**From:** Sarah Fletcher <fletchsa1@gmail.com>  
**Sent:** Sunday, March 26, 2023 4:51 PM  
**To:** Roxanne Navrides  
**Cc:** Ryan Harriman; Suzanne Skone; Dan Thompson; Mike or Susie Cero; Carv Zwingle; Thomas Acker; Council; Traci Granbois; Robert Medved; Jessi Bon; Alison Van Gorp; Bio Park  
**Subject:** Re: Public Comments SUB 19-002/Boys and Girls Club Long Subdivision

Dear Ryan, I am a long-time resident of Mercer Island, and have been involved in this subdivision since the property was originally purchased from the Boys and Girls Club, a very unfortunate situation. The purchasers never honored their promise to build and provide ballfields for Island youth and the city never required a deed on the property despite the fact the Boys and Girls Club, city, and private citizens spent several million dollars to build Peak rather than buy this parcel for roughly the same price. Many citizens, and council members, felt deceived.

SITE PLAN
2825 W MERCER WAY
PRELIMINARY PLAN
PARCEL #2174502425
CITY OF MERCER ISLAND WASHINGTON

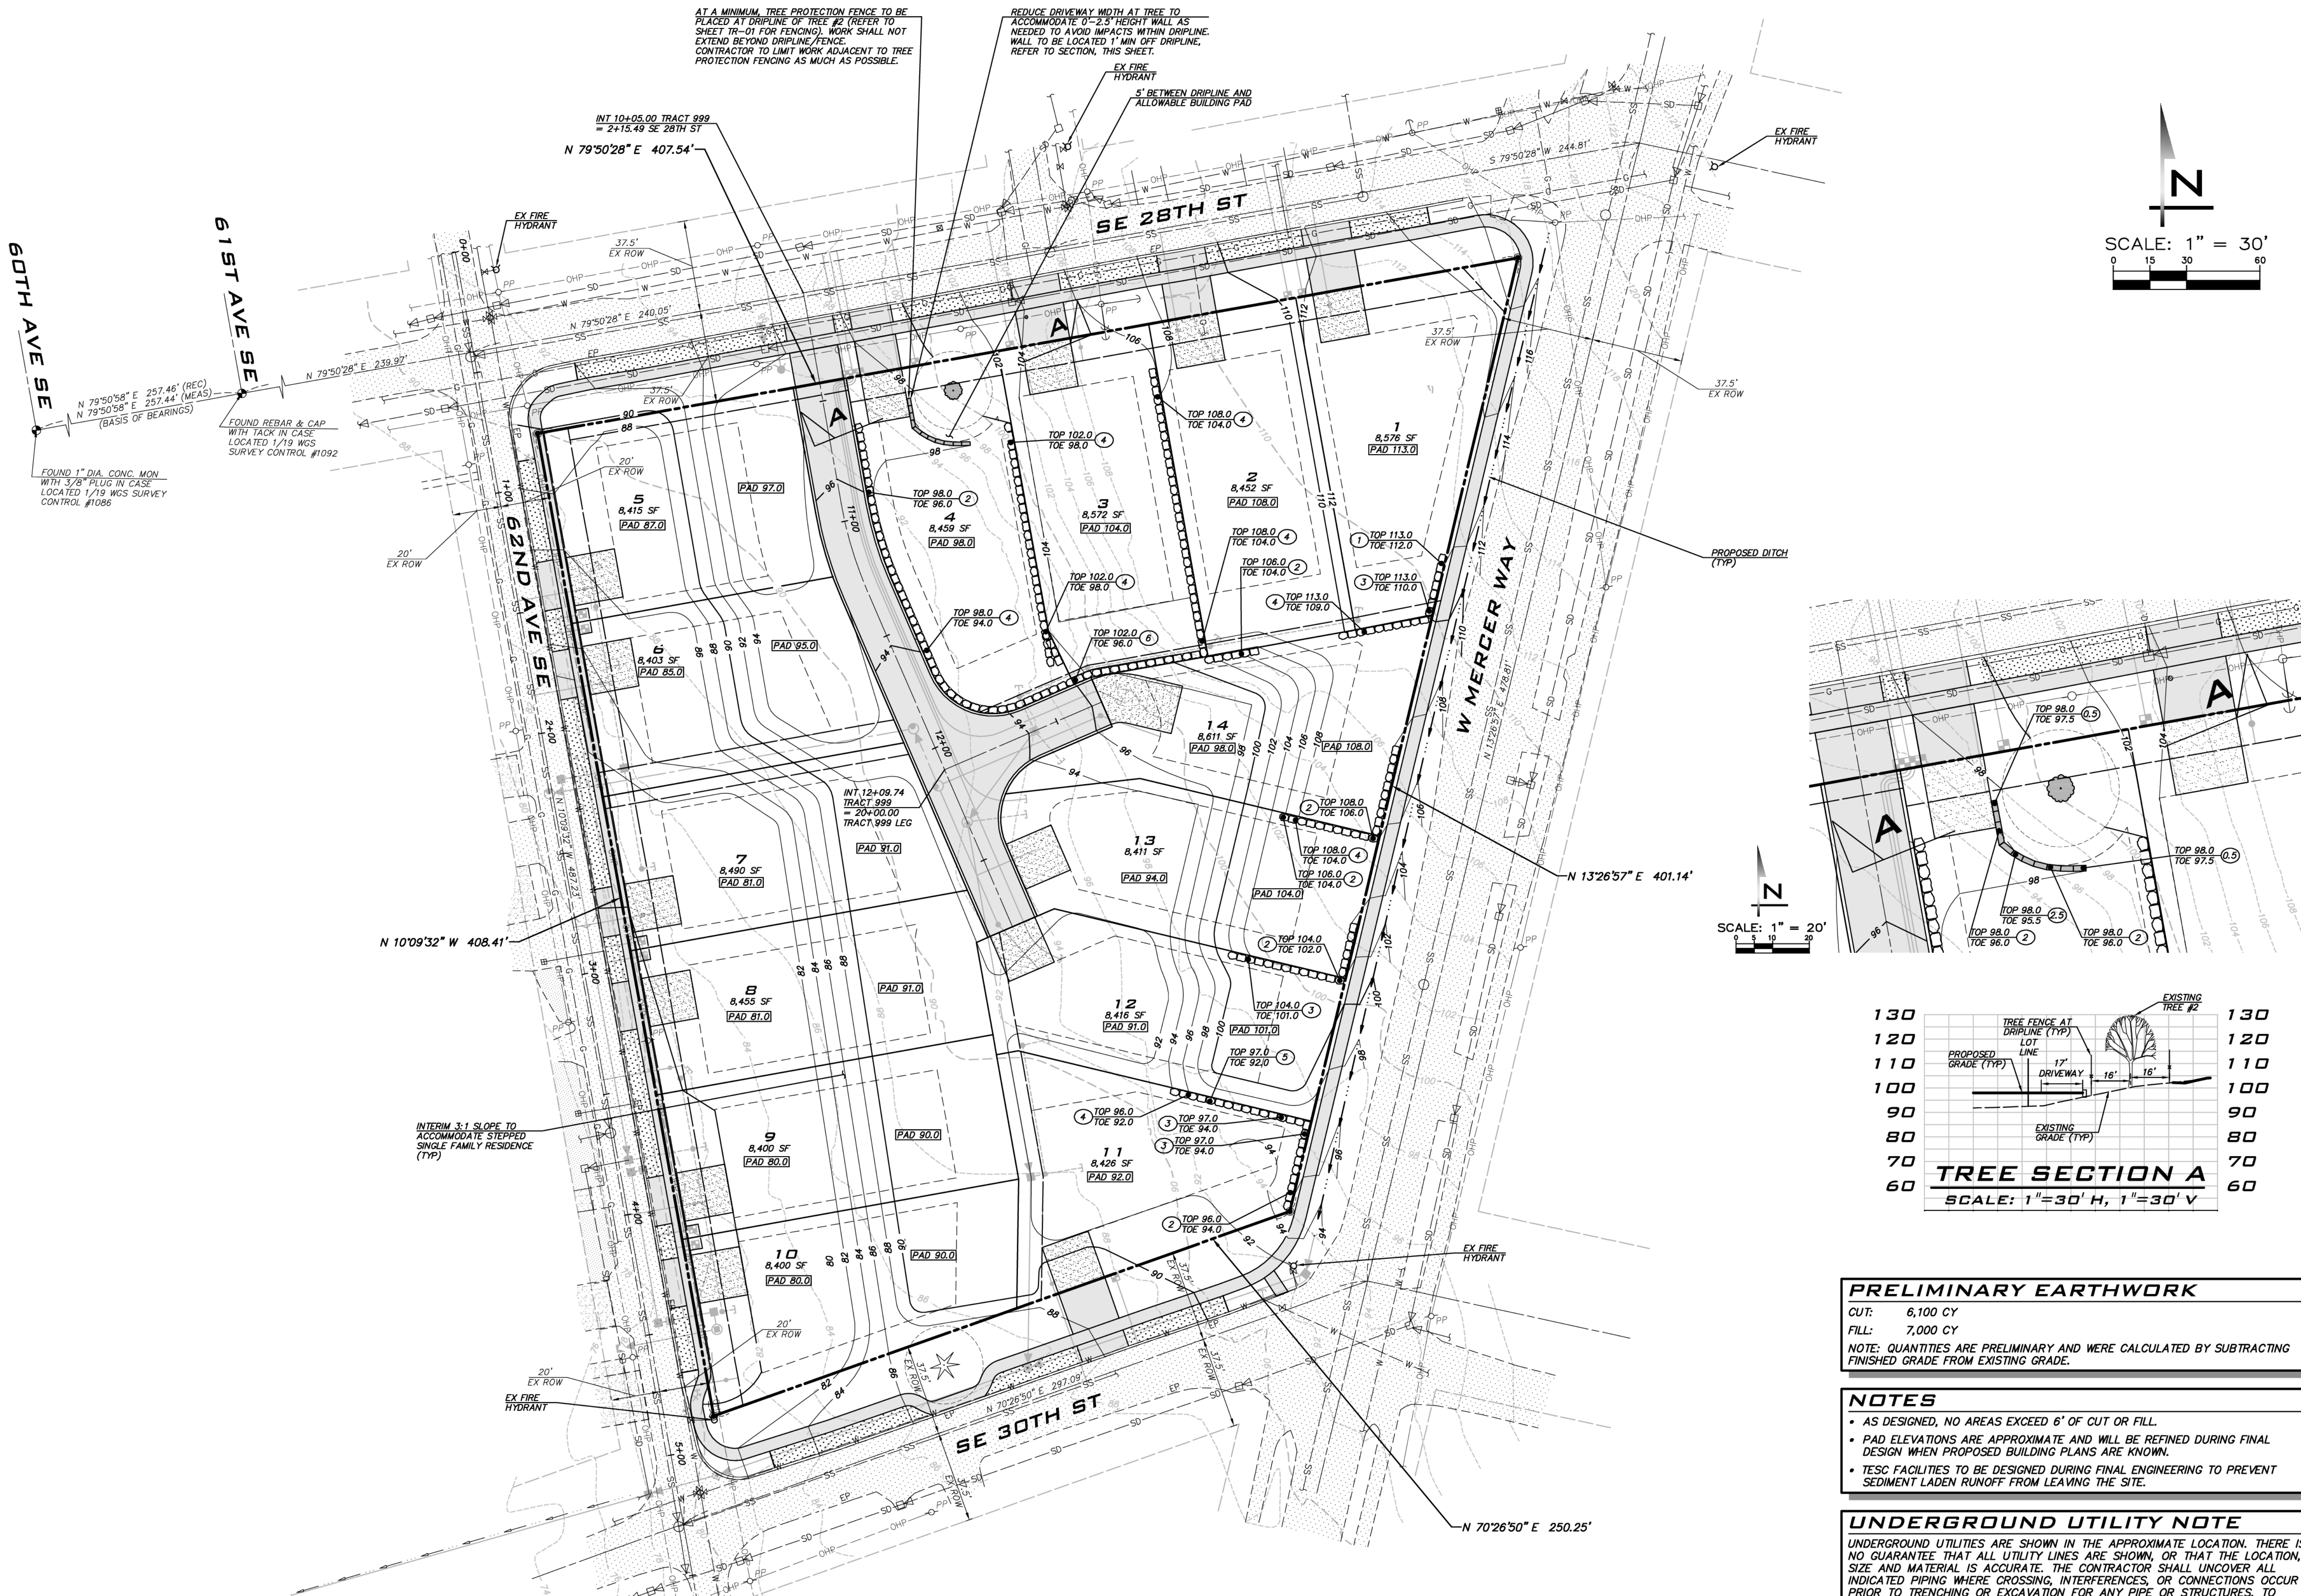
A. There is no green space at all, despite the demolition of an historical building and removal of many mature trees. I believe some green space setaside should be required as in the original plans although it reduced the total number of lots from 14 to 13.

B. Ingress and egress should be by internal road for each house. The applicant no doubt does not like this since the internal road counts against lot area and lot coverage limits, but in my opinion the current plans are a danger to those walking or biking along adjacent streets. There is some internal access to some lots, but all access should be by an internal access road.

My belief is the MICC requires the applicant to set aside an area equal to one lot for green space, and all access should be by internal roads. These are the same findings Evan Maxim made if you review his file, and were the findings of the council in the Coval long plat process.
